No.	LLFA Objection	AECOM Response
1	<p>Provision of evidence to show the surface water flood risk noted within the Flood Risk Assessment (FRA) will not impact the extension. This may include consideration of ground levels around of the existing and proposed buildings, access points to buildings and how the existing drainage network will interact with the new extension (e.g. surcharge of a network designed to out of date standards). As no updated Flood Risk Assessment has been provided, this point remains outstanding.</p>	<p>Volumetric survey has been completed to review existing flood risk and assess/mitigate impact from proposed development. (Section 3.5). Proposed valley will provide 175mm of freeboard for the proposed development.</p>
2a	<p>Evidence of how the Drainage Hierarchy was applied in line with the Defra Non-Statutory Technical Standards, industry best practice and HCC SuDS Policies within the Local Flood Risk Management Strategy 2 (LFRMS2). This includes evidence on why infiltration is not possible for the extension drainage network, such as evidence of ground conditions / underlying geology and permeability including BRE Digest 365 infiltration tests as referred to as

Existing Drainage Layout (ESL-ACM-XX-ZZ-DR-C-0500)

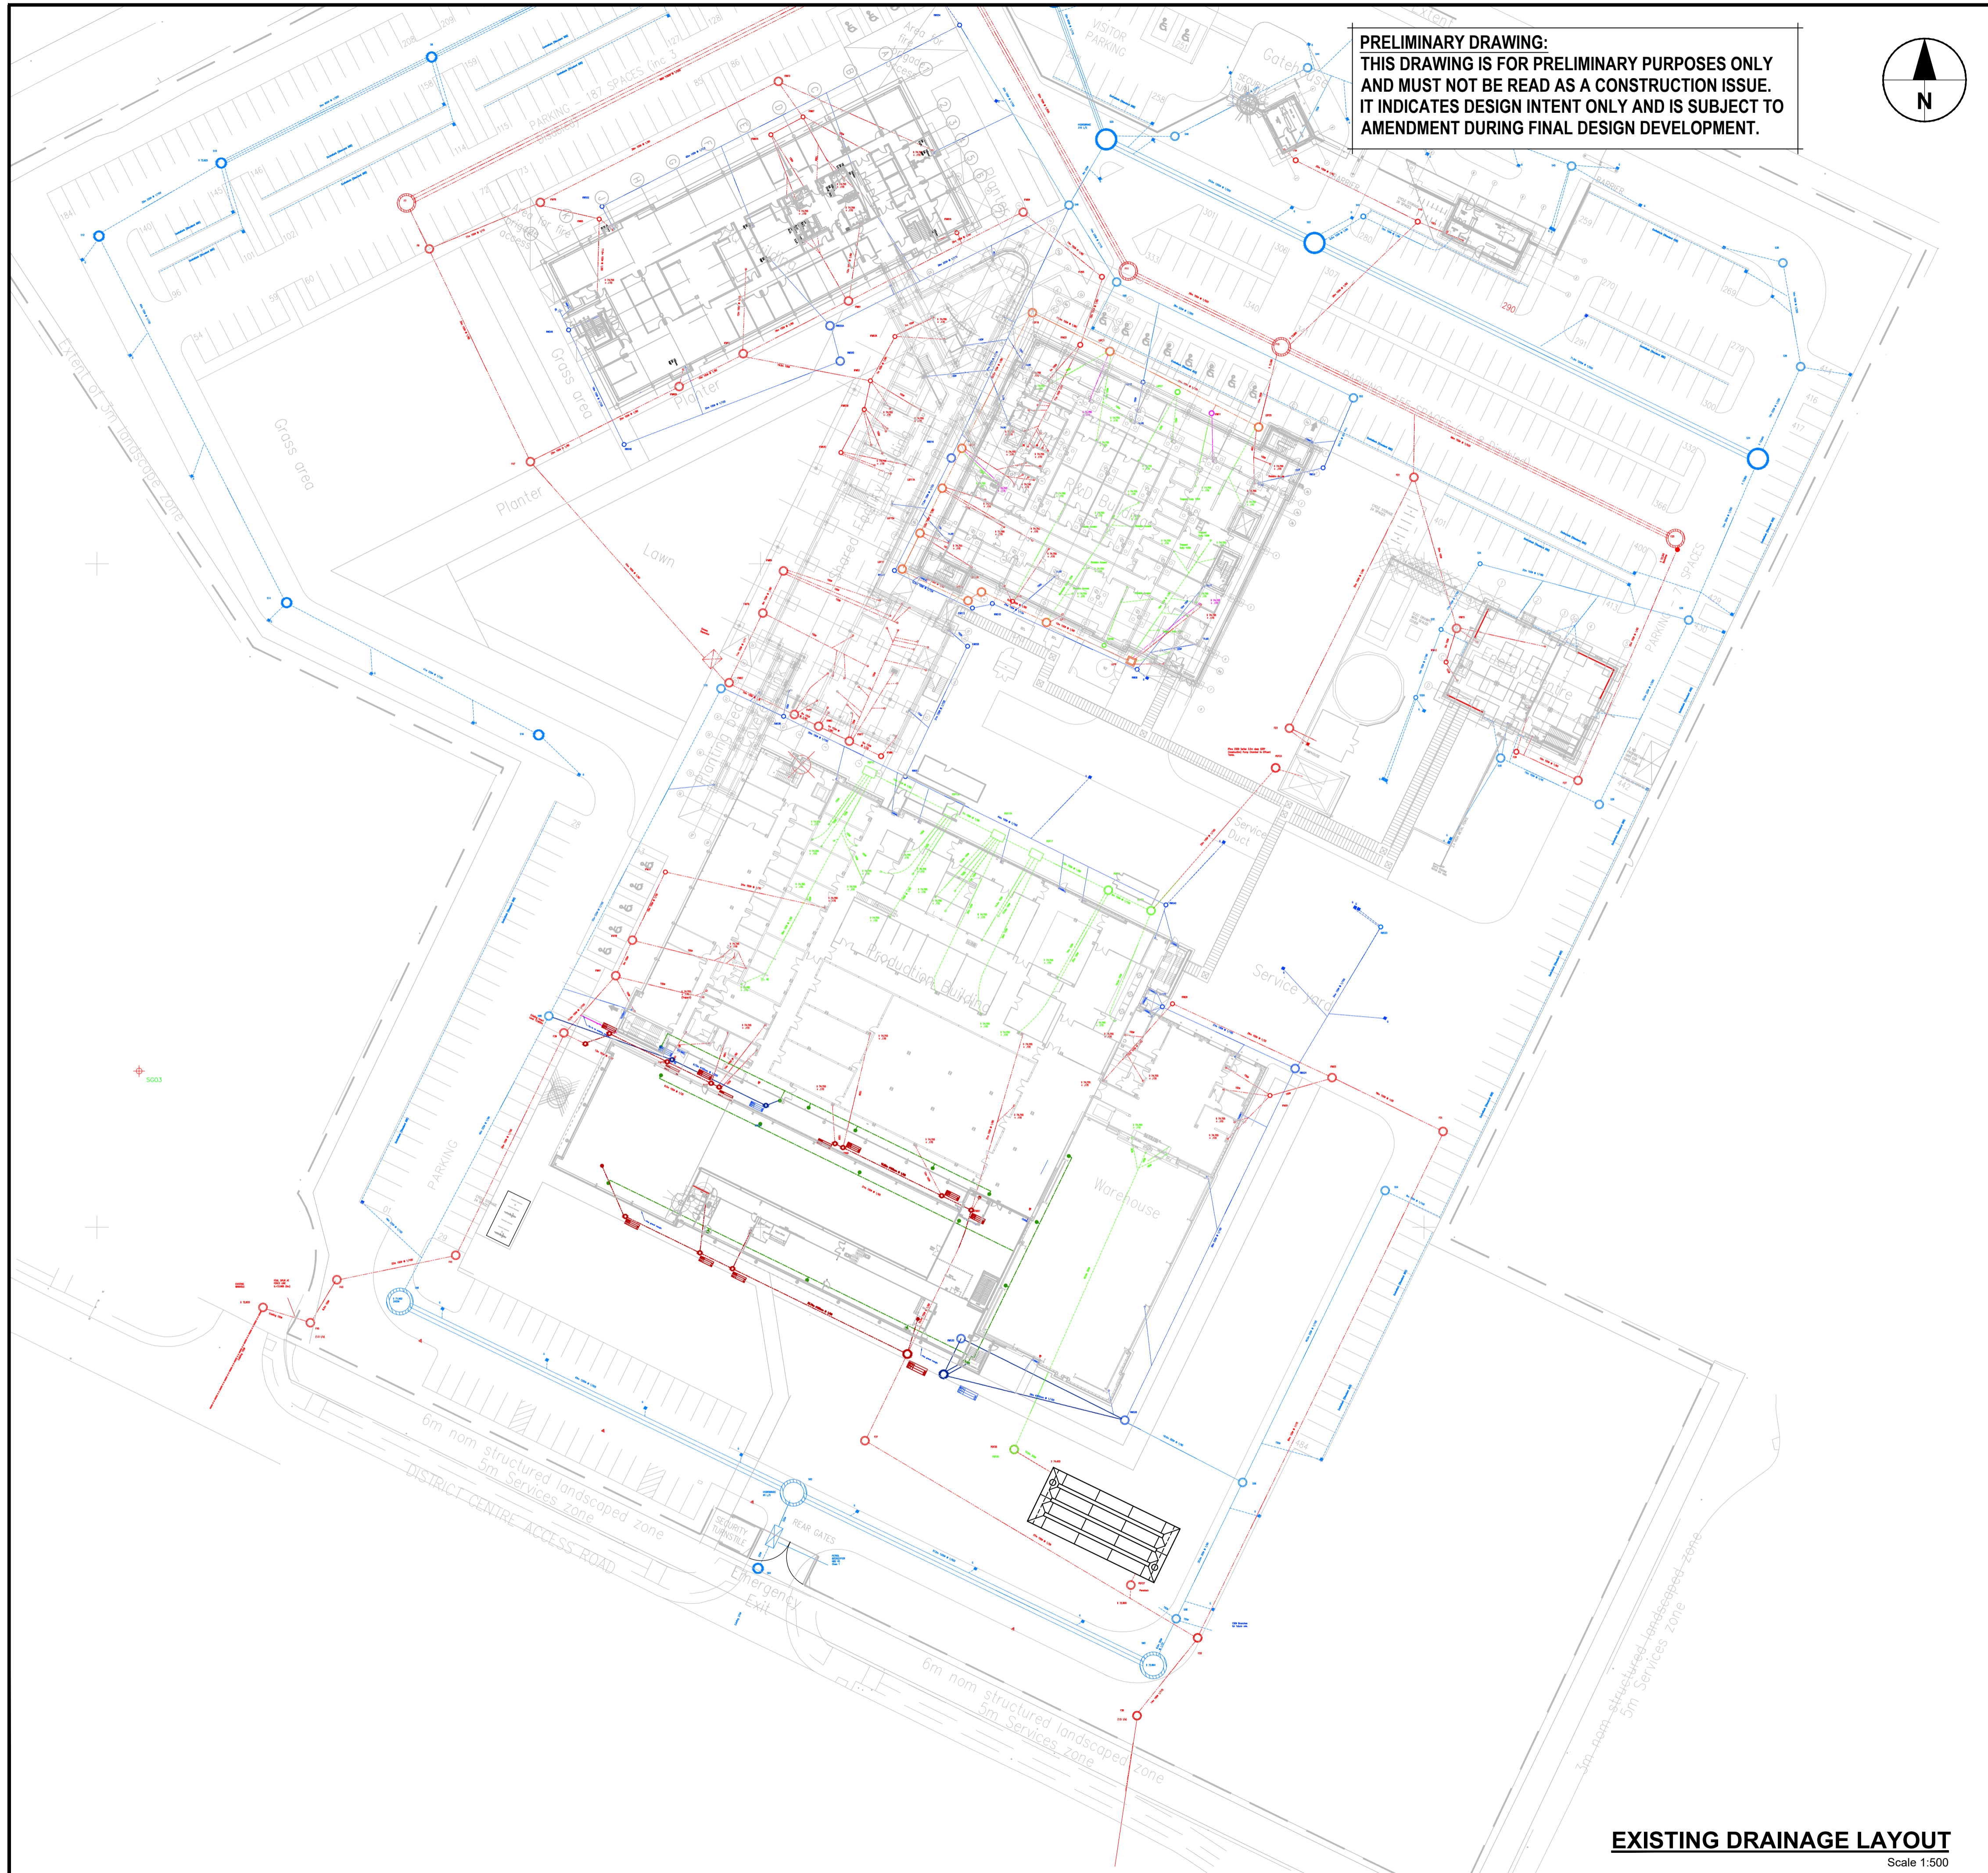
2d	<p>A full detailed drainage layout plan showing the proposed SuDS features, any associated manhole cover and invert levels, proposed ground levels, pipe sizes and gradients, all online controls, online and offline storage structures, water quality mitigation and outfall details has been provided however, based on the proposed phasing plan (Drainage Strategy Figure 2-3) it is unclear whether all relevant areas are included in the proposals in the Appendix D. We await clarification and recommend an impermeable areas plan is prepared.</p>	<p>Impermeable Areas Plan provided in Appendix D (Drawing ESL-ACM-XX-ZZ-DR-C-0520), with additional explanation provided within Section 3.4.</p>

SHEET NUMBER
ESL-ACM-XX-ZZ-DR-C-0502

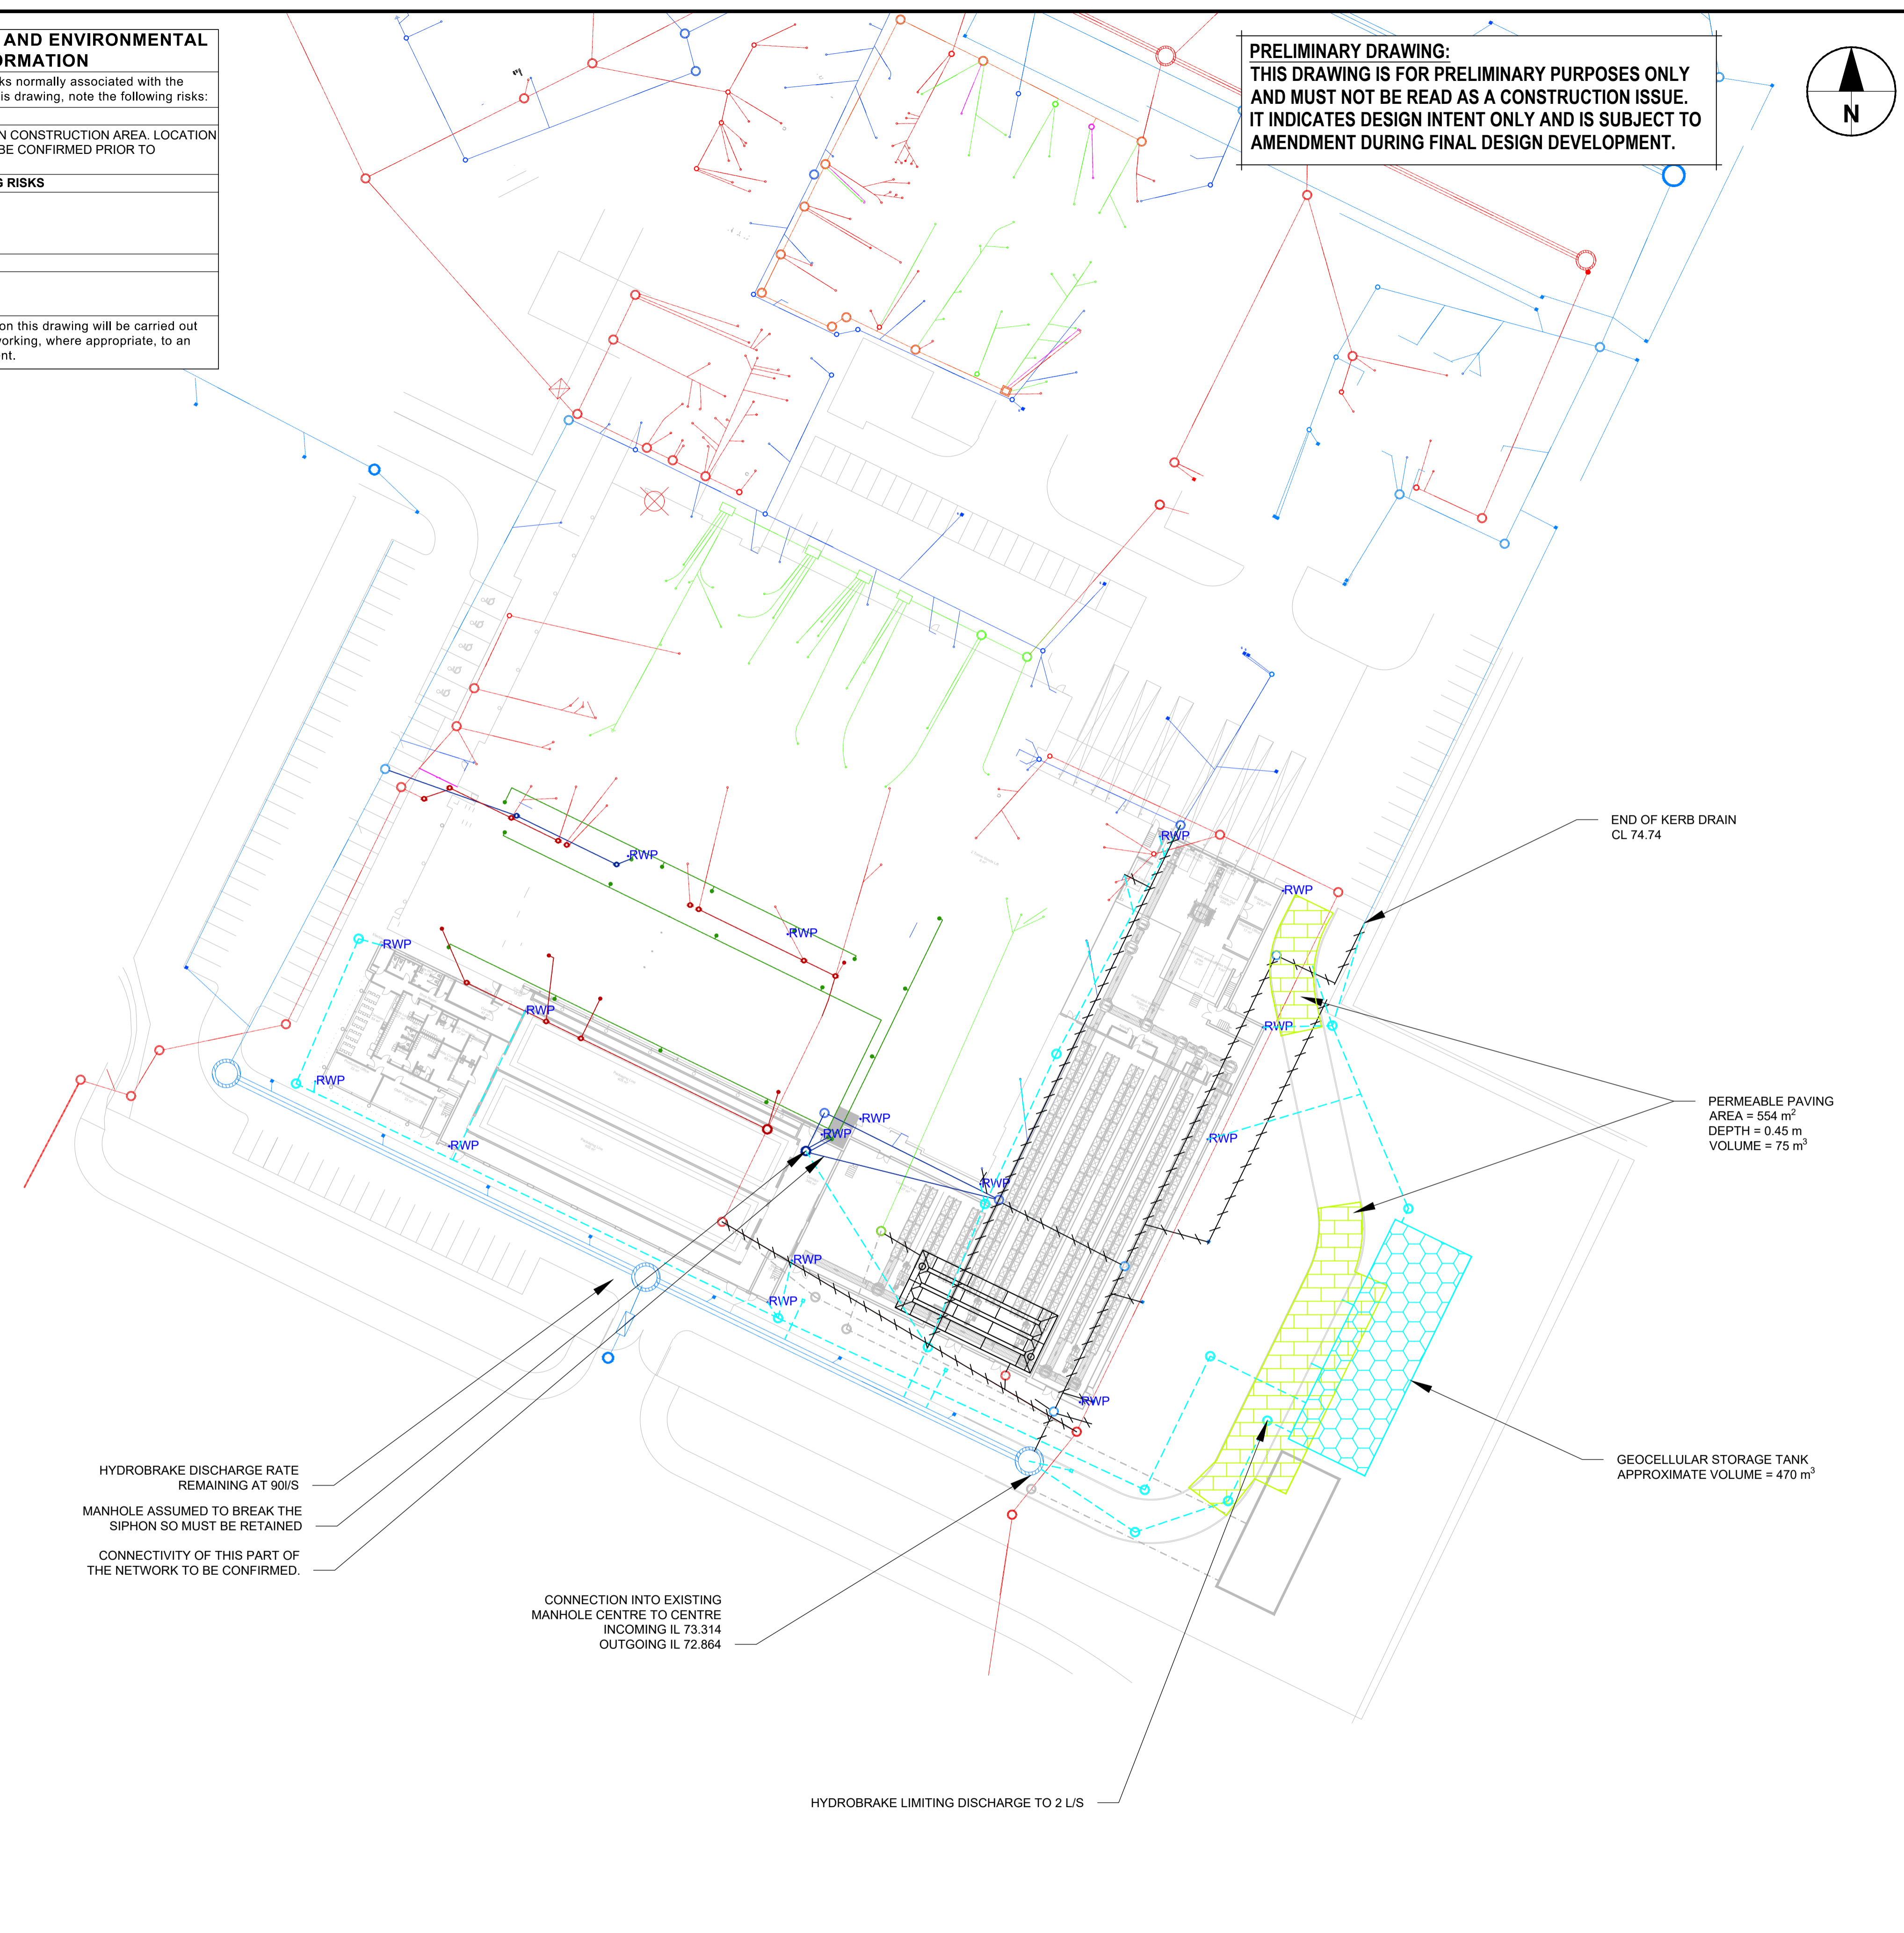
5	<p>We require clarification on why the permeable paving along the road is broken up into two sections given the topographic survey does not highlight any steep area. We require justification why permeable paving cannot be used throughout the whole of the proposed internal road to add an additional layer of treatment. We require the application to provide clarification on the levels of treatment for the proposed road which ties into the existing road to the west and south of the site. Additionally, the applicant shall provide detailed engineering drawings for the proposed site which includes each of the proposed drainage elements.</p>	<p>Additional permeable paving has now been provided between the original two sections. However the effective storage of this section is considered negligible, in accordance with SuDS manual guidance. This also applies to other non-permeable paving sections of the road, due to restrictive gradients. Further sections of road are to remain as existing, and therefore have not been incorporated as part of a permeable paving network. All surface water drained by the proposed network will pass through the downstream defender, which will provide sufficient treatment for the pollution indices present on site. Further information can be found in Section 3.6.2.</p> <p>Detailed engineering drawings will be provided as part of further detailed design stages.</p>
